Householder Proforma

Application Ref: 2021/0474 Address: 46 Hollins Wood Grove, Cudworth, Barnsley, S72 8TB

Proposed Extension: Erection of two storey side/rear extension to dwelling

Drawing Title **PROPOSED ELEVATIONS**

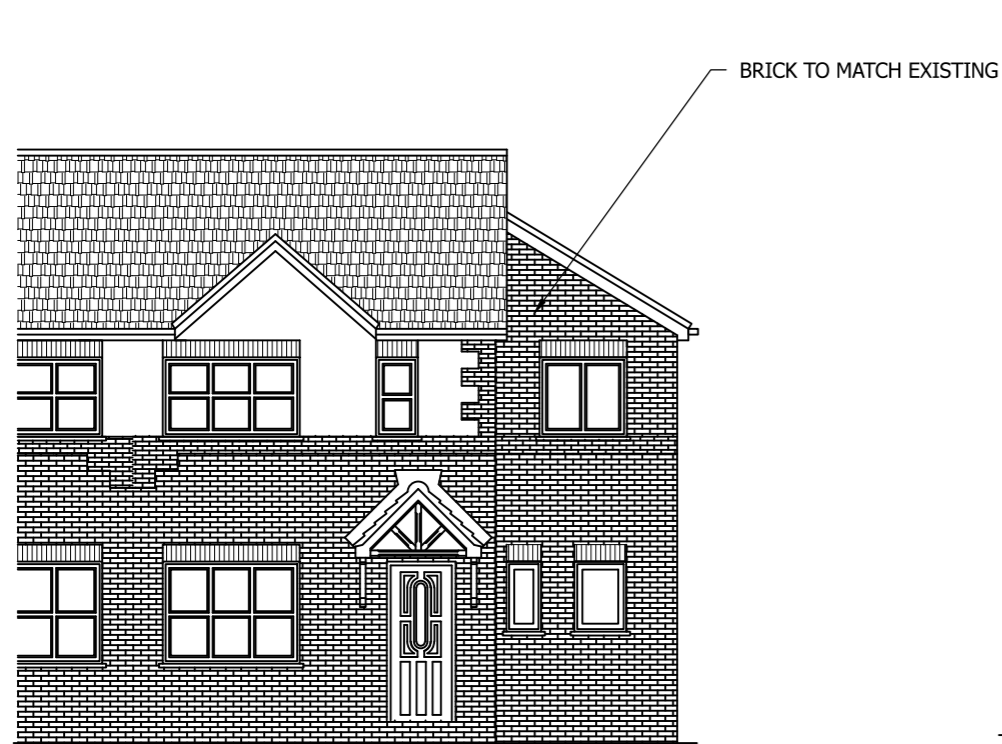
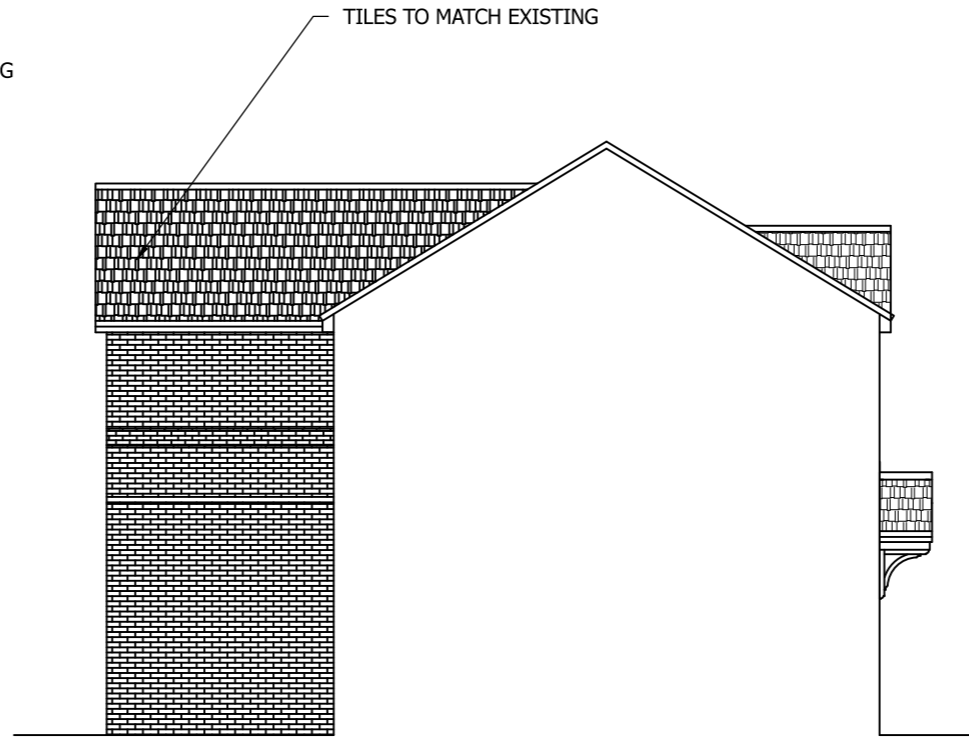
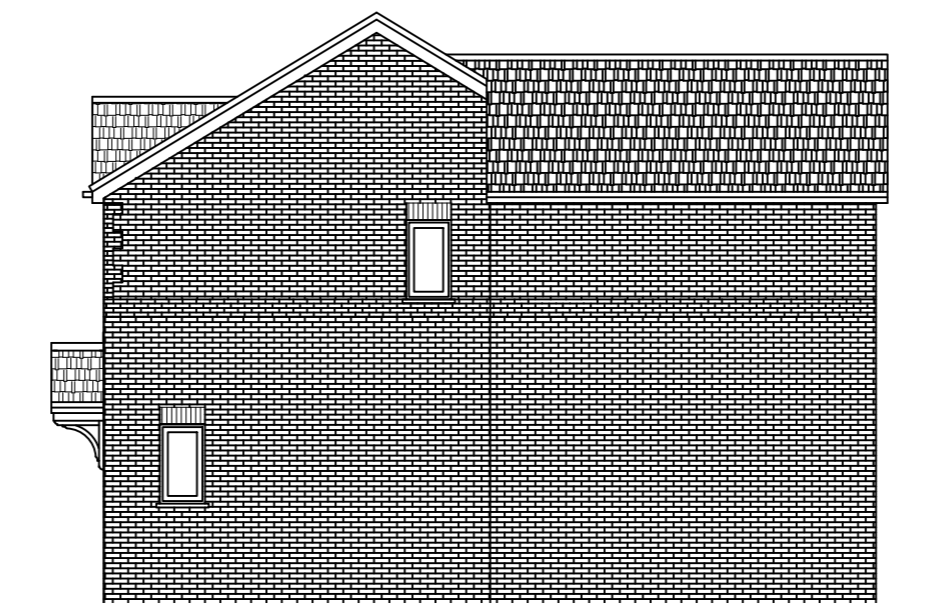
Yes / No (include comment if required)
Single Storey	
1. set back	Yes
Two Storey / First Floor	
2. set back / set down (500mm minimum)	Yes
3. less than 2/3 the width of the original dwelling	Yes
All	
4. roof design corresponds to existing	Amended plans have been received which see the roofline of the extension as a continuation of the existing.
5. windows / doors of a similar design / proportion	Yes
6. habitable room windows on the side elevation	No
7. materials to match	Yes including matching blockwork
